**RE: Revised Grading Plan (F11-1D014G  
Lot 32P1 Oxbow bluff  
Albuquerque, New Mexico**

The purpose of this letter is to accompany the enclosed revised grading plan. The plan has been revised to accommodate your written comments dated 12/30/14. The following is a summary of your comment and the narrative as to how we addressed

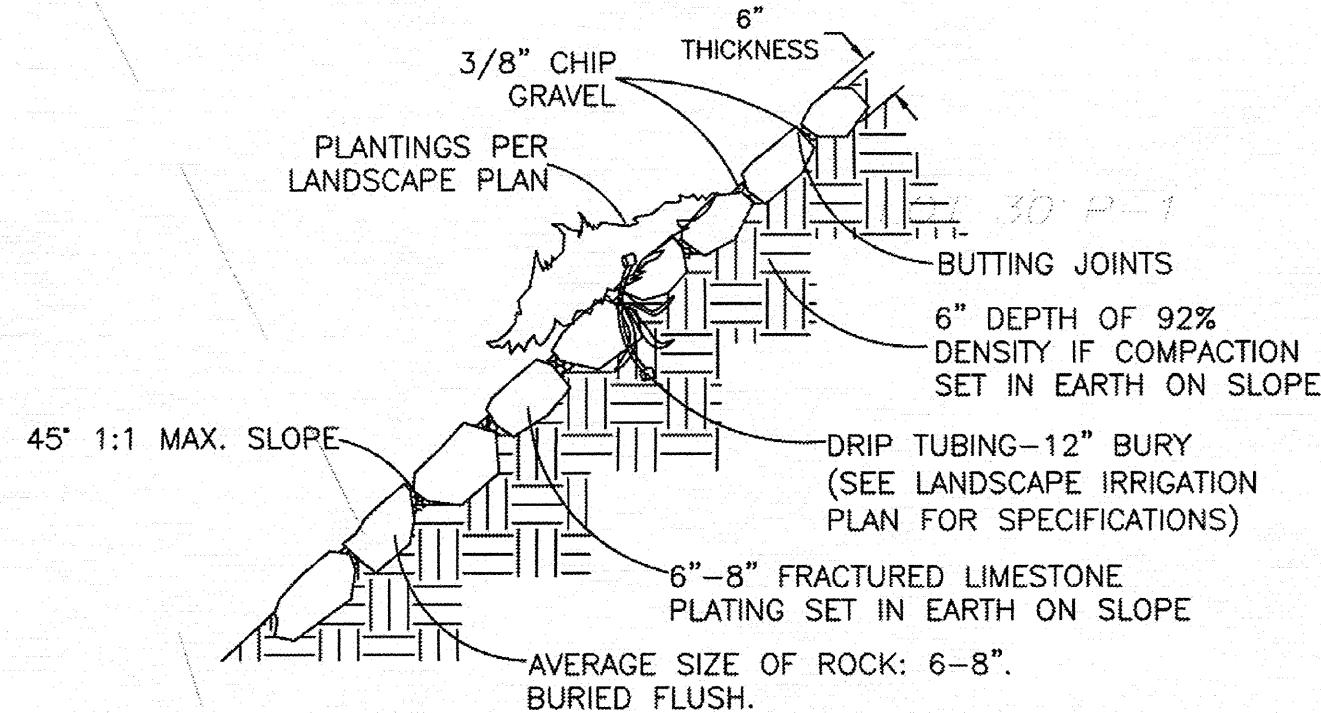
1. Show Mwsel, overflow and contours on pond  
**We have added the overflow and contours. Since the pond is a water quality pond only the water surface elevation will be the spillway. The entire contributing basin generate a peak of 4.1 cfs, the spill way has a capacity for 20.8 cfs. We have shown the entire lot that shows the existing inlet outfall**

2. Provide drainage narrative.  
**We have added the narrative the plan**
3. Provide benchmark  
**We have added the benchmark.**
4. Show property liners.

7. Show roof drains and flow directions  
**We have added**
8. How is offsite handled  
**We have included a basin map for the contributing area. The city AGIS map with 2' contours was utilized but the website will not allow print outs. So the County GIS was used to show. The flow is allowed onto the site and drains through the first flush pond, the overflow has capacity for entire upland flow to safely pass.**

9. Were is public drainage easement  
**We have shown entire property including referenced easement.**

10. Where is oxbow main outfall?

11. Show flow arrows and contours

**We have shown the inlet we are draining to on the plan set**

**We have added the contours for the plan**
